Ribble Valley Borough Council
Housing & Development Control

Application no: **3/2023/0488**

Address: **The Old Printworks 4a and 6a Back York Street Clitheroe BB7 1LT**

Proposal: **Change of use to three dwellings including demolition and rebuild of brick extension to create three storeys.**

Proposed Floor Plans 1:100 @ A3

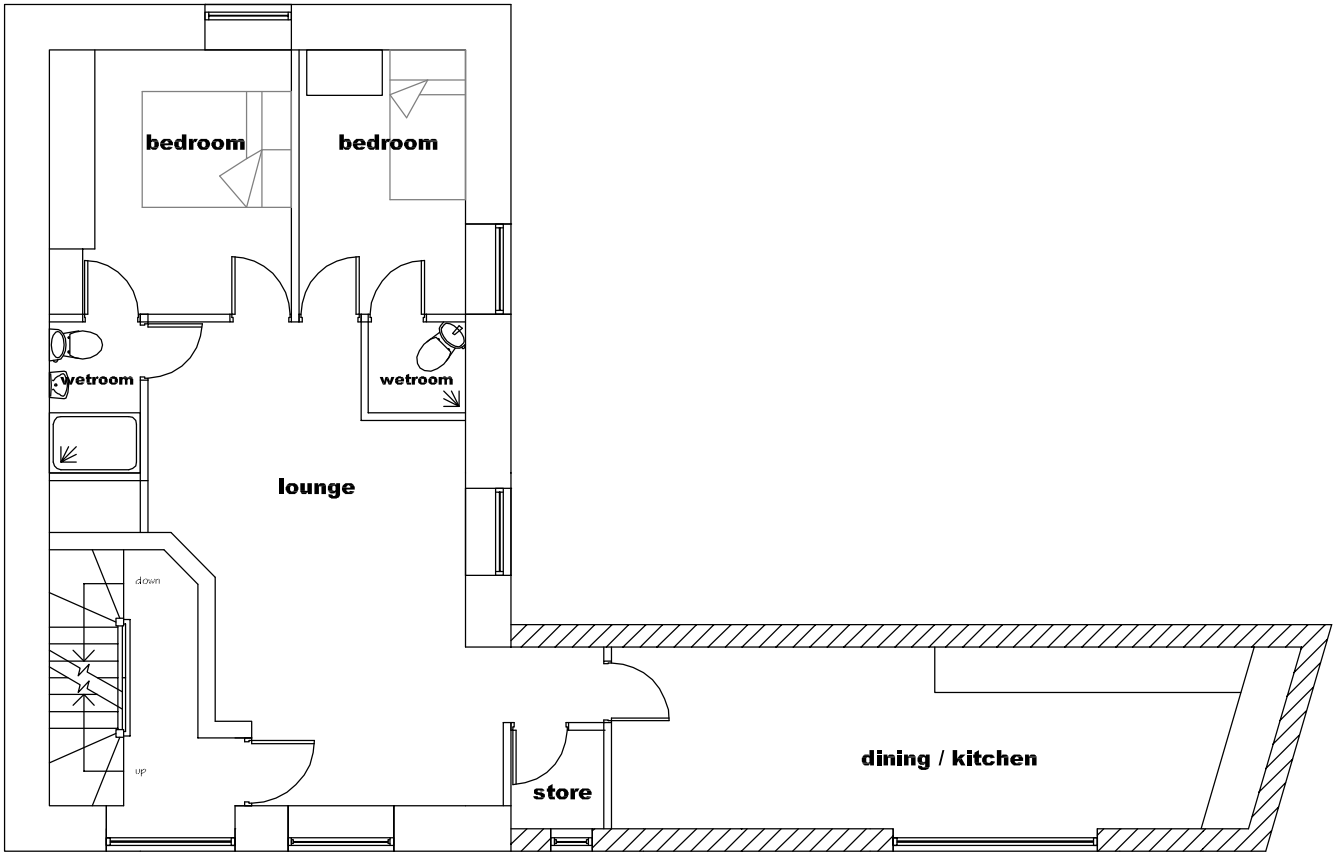
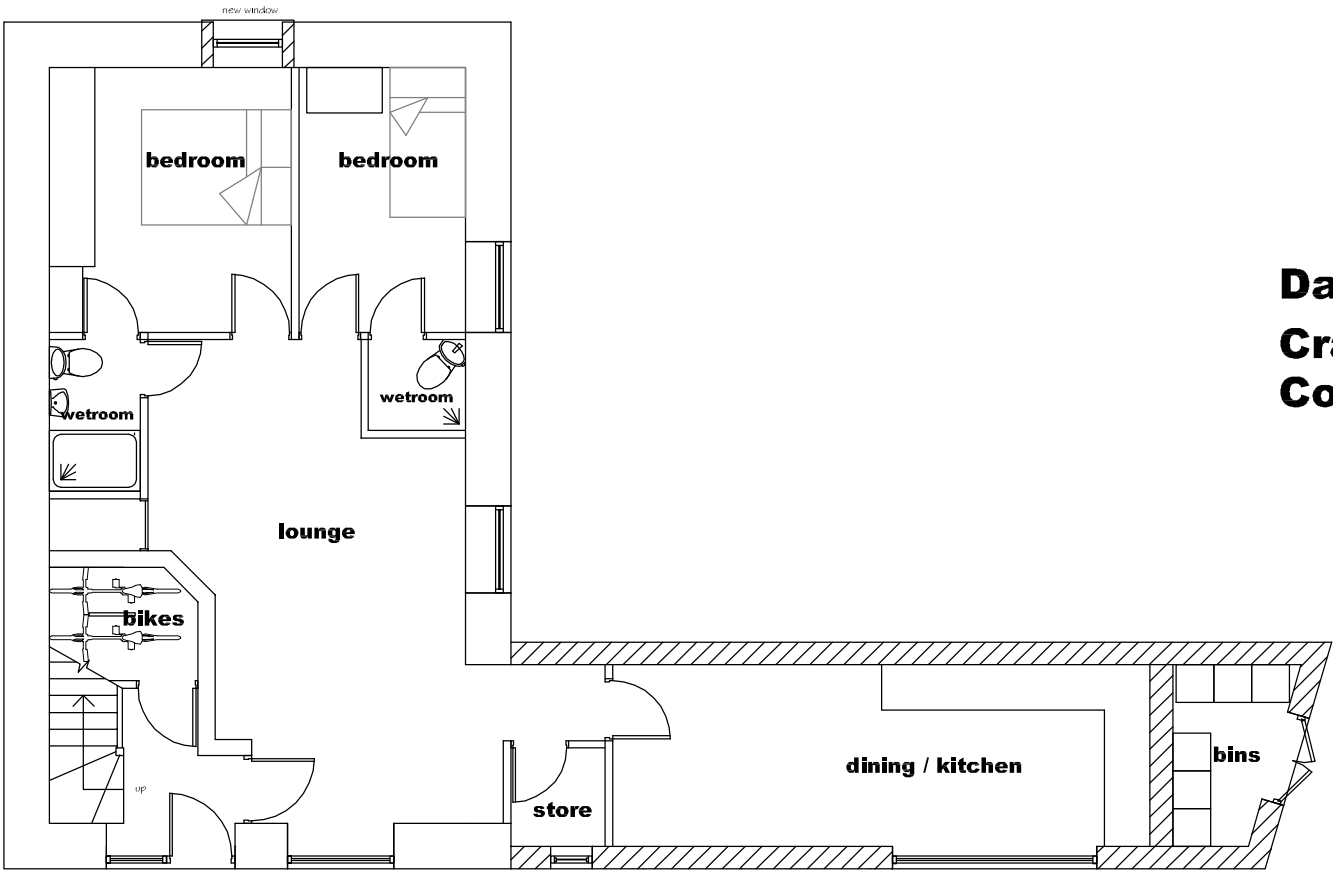
However, the LHA have reviewed the drawing titled "Proposed Floor Plans" and are aware that an internal, shared cycle store will be provided for the apartment block which the LHA welcome but there is only space for 2 bikes. Therefore, the LHA require that a minimum of 3 cycle spaces are provided in the internal store.
